Resident Committee for HKH Redevelopment Project

State Significant Development Application: Hornsby Ku-ring-gai Hospital Redevelopment Stage 1

Application Number – SSD 5356

A. Proposed location amended site plan
(blue shaded area)

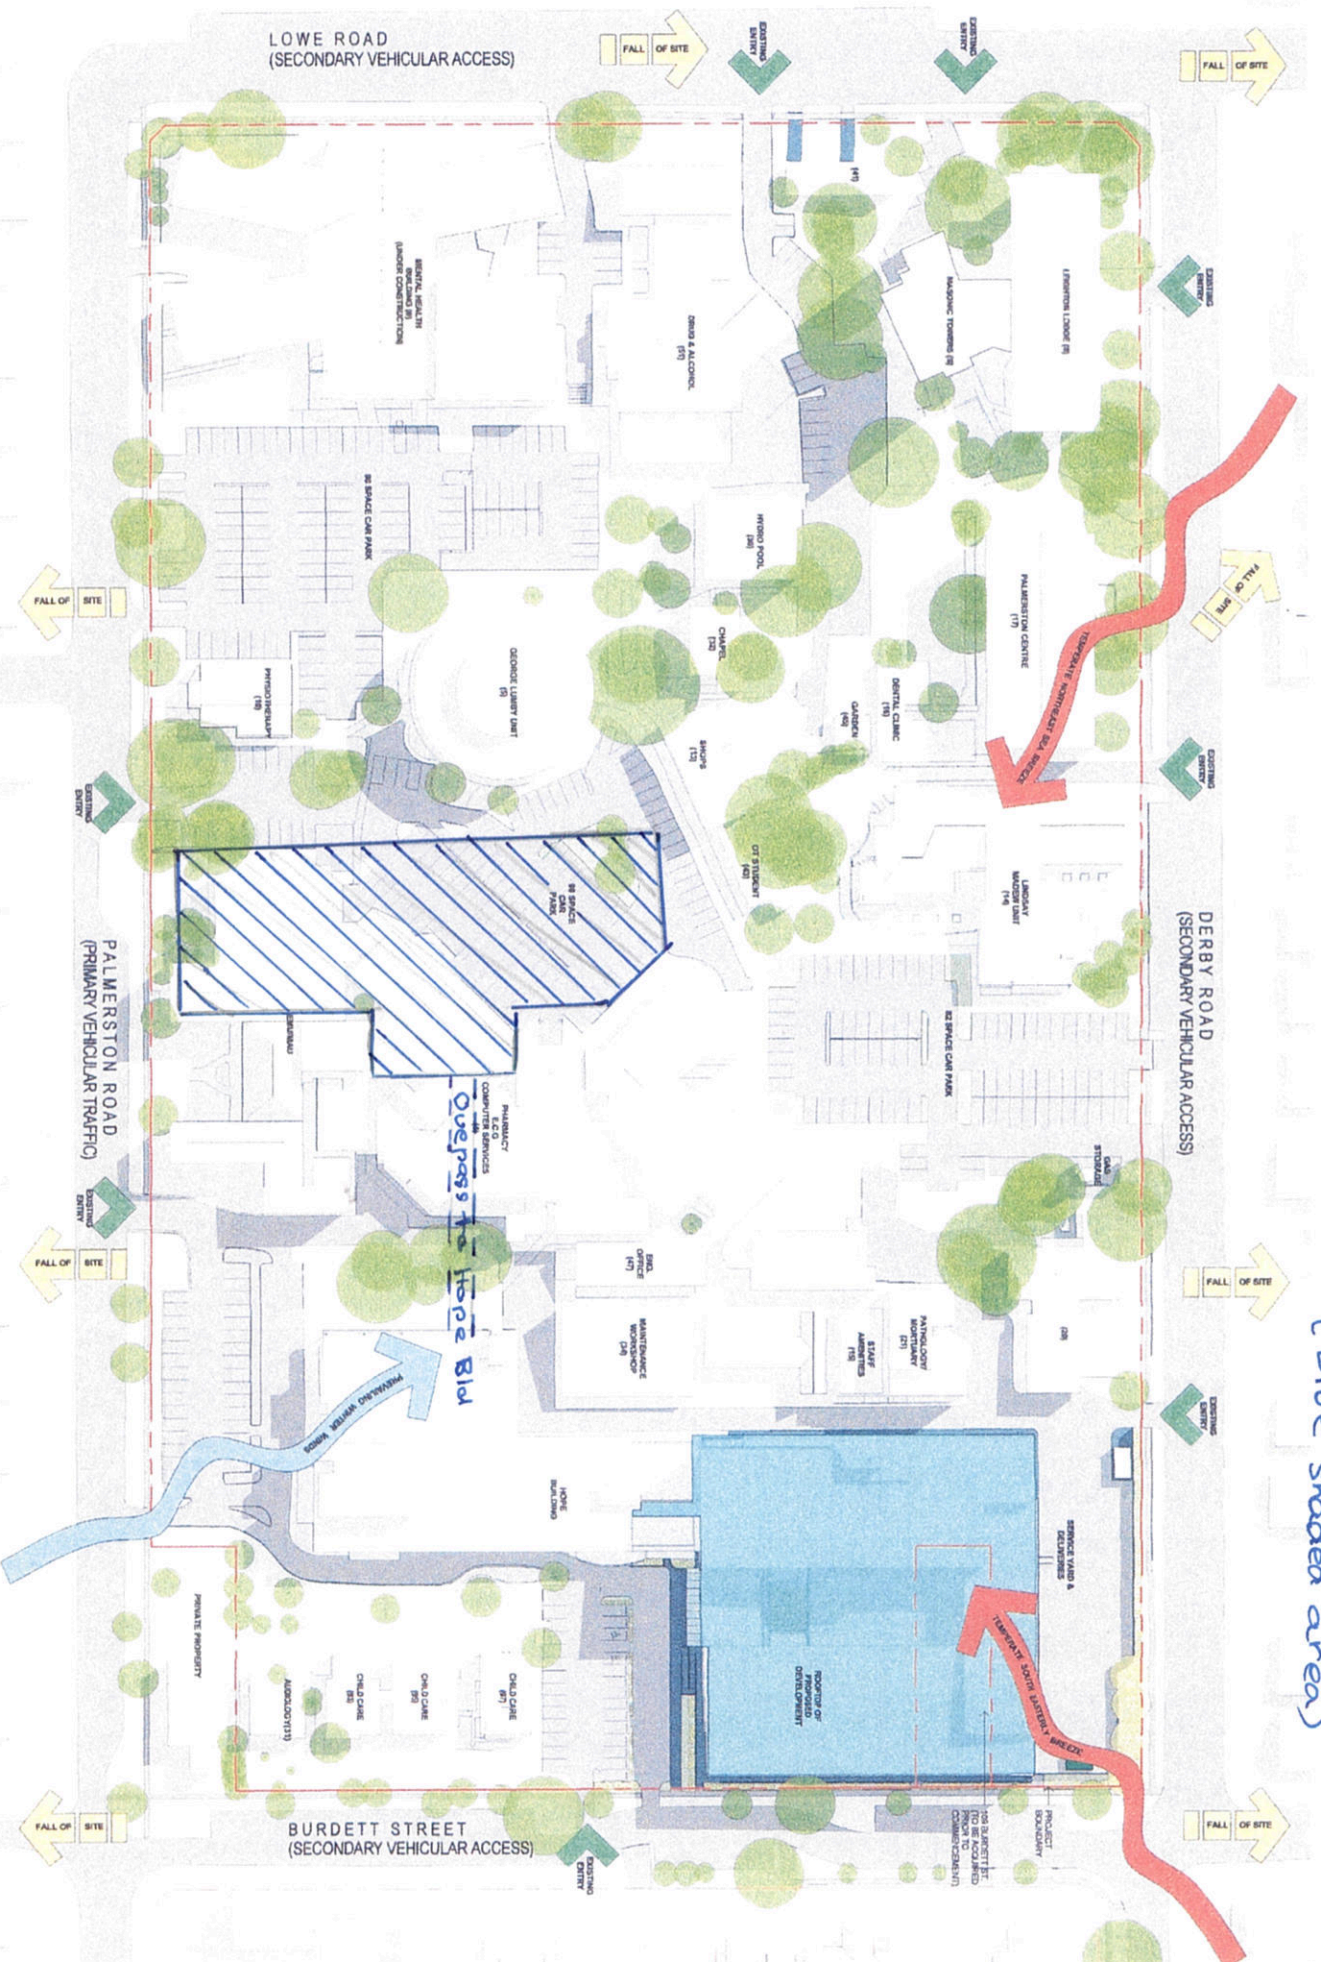
The actual location of the facility itself on the Burdett Street and Derby Road sides of the campus brings with it most of the issues that are raised herein by us. Location on the Palmerston Road side of the HKH campus either directly on that street front or centered adjacent to the existing Lumby Building and across the grounds that now are occupied by old single storey buildings (Pathology and the old Emergency Wards). (See Appendix 1 - Amended Context Analysis Site Plan A)

Consequently, the Resident Committee makes a submission to re-site the building to the Palmerstone Road side of the campus. Whilst we understand that this would require amendment to the footprint and thus incur some design costs we submit that it is a site that provides long term

B- Proposed Amendment to Building Footprint
(blue dashed line)

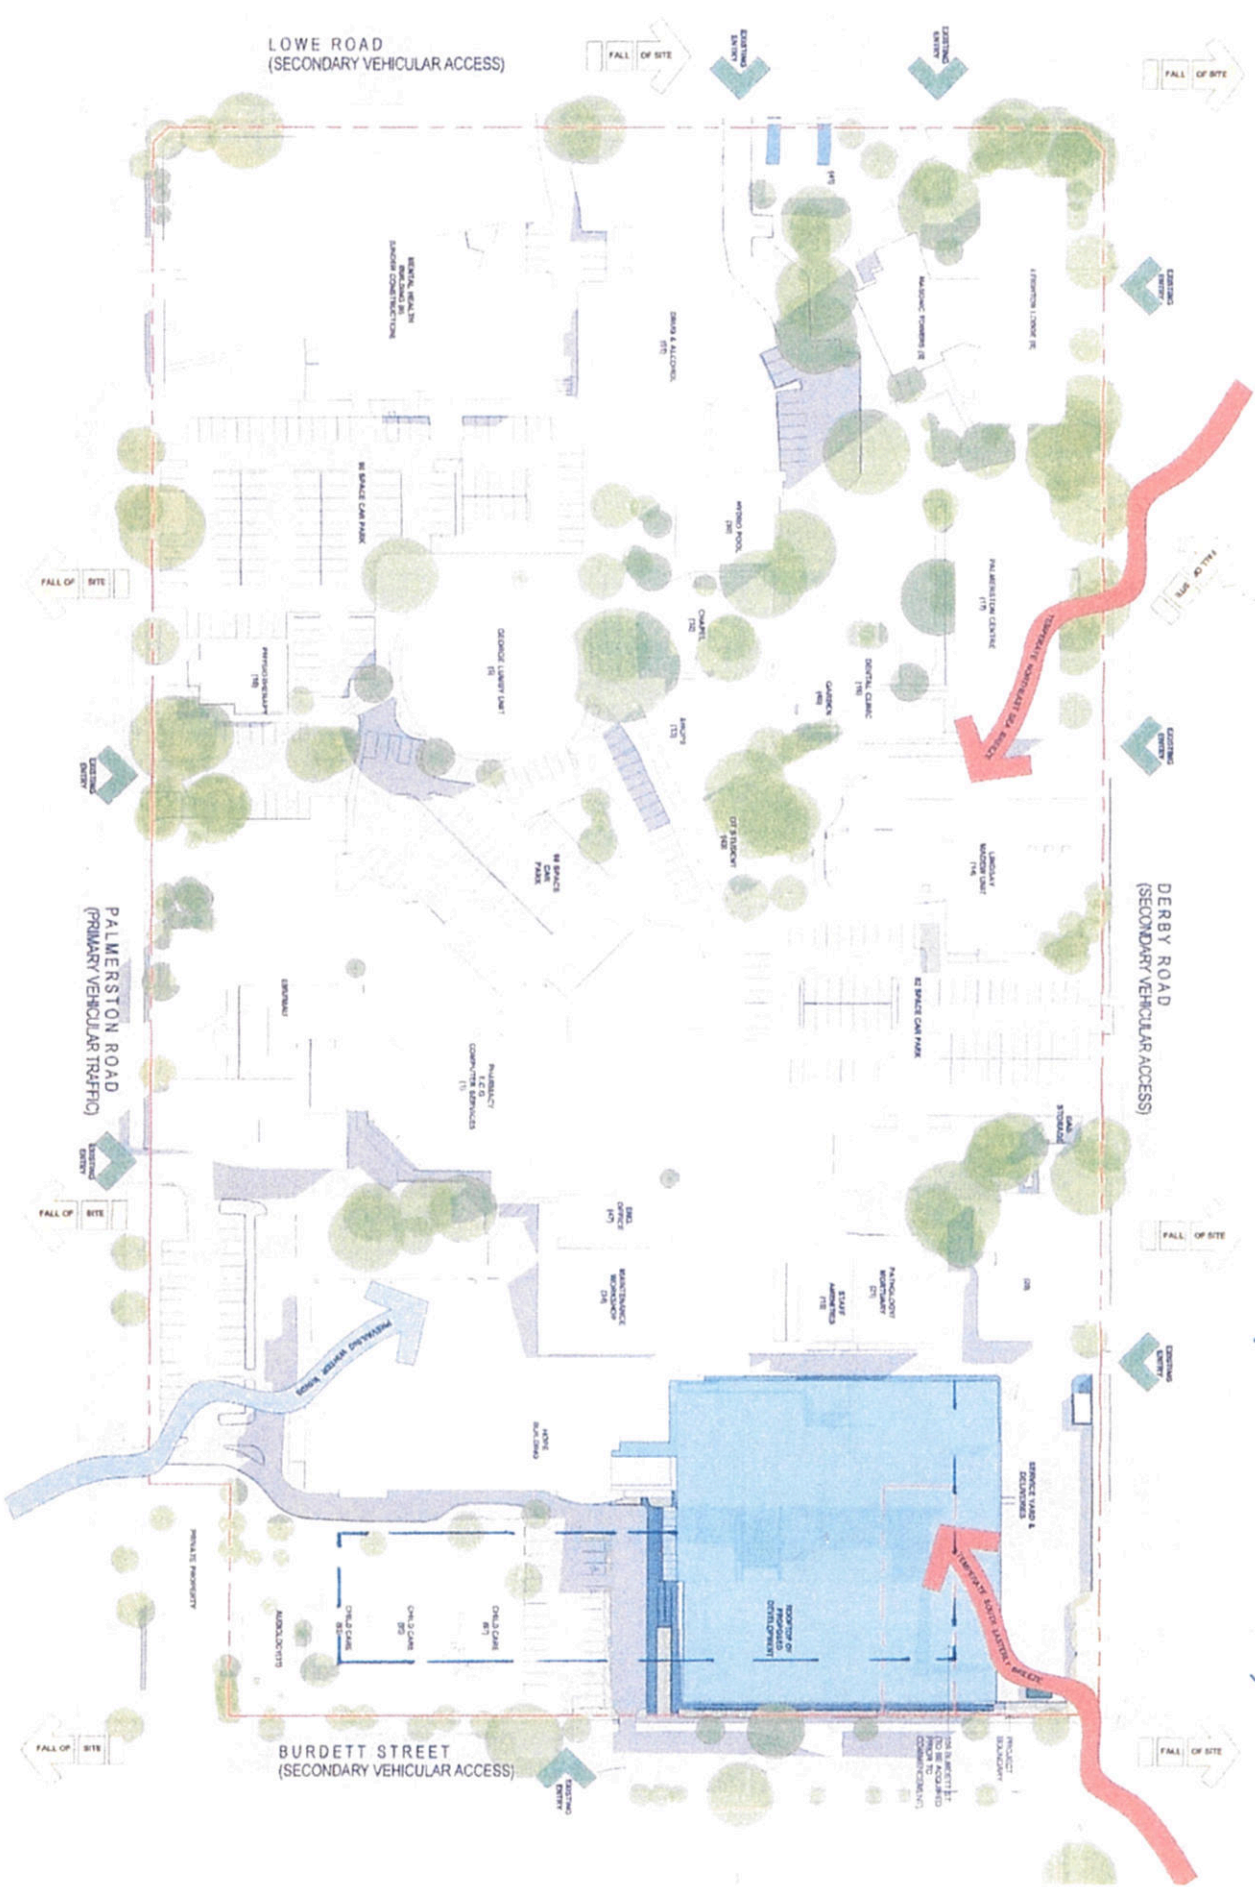
To the west of the proposed building and facing Burdett Street lie four existing old cottages owned by Hornsby Ku-ring-gai Hospital. Three of the cottages currently house hospital run child care facilities and one houses an Audiology unit (Woodhead Architectural Statement V3.0 - Context Analysis Site Plan). Provision of child care facilities for staff is not core service delivery for the hospital. Current children attending in these facilities are 50% children not related to hospital staff. The immediate locality already provides 12 excellent and readily accessed existing childcare facilities. (See Appendix 2). The existing houses could be demolished to increase ground space available for the Stage 1 Redevelopment.

The existing Audiology unit could be easily relocated and the child care facilities closed with minimal impact to core hospital services.

This makes available an estimated additional 250 square meters of ground space into which the new facility could be extended whilst still retaining its functionality and integrity. (See Appendix 1: Amended Context Analysis Site Plan B). Thus would allow for a narrower building, an increased set back from Burdett Street and Derby Road, less overshadowing and visual impact and more effective planting of trees to provide screening.

Existing entrance way to the car proposed car park and new entrance could be retained as an underpass through the proposed ground floor undercroft (thus maintaining ambulance access to the Hope Building as well as the new facility). Proposed linking connections to the Hope Building would be retained. Levels 3 and 4 have inner voids designed into them that would lend themselves to being moved to accommodate a longer lower building than that proposed. The sterile zones in the upper storeys of the building could be maintained and their location also adjusted to a longer and narrower building shape.
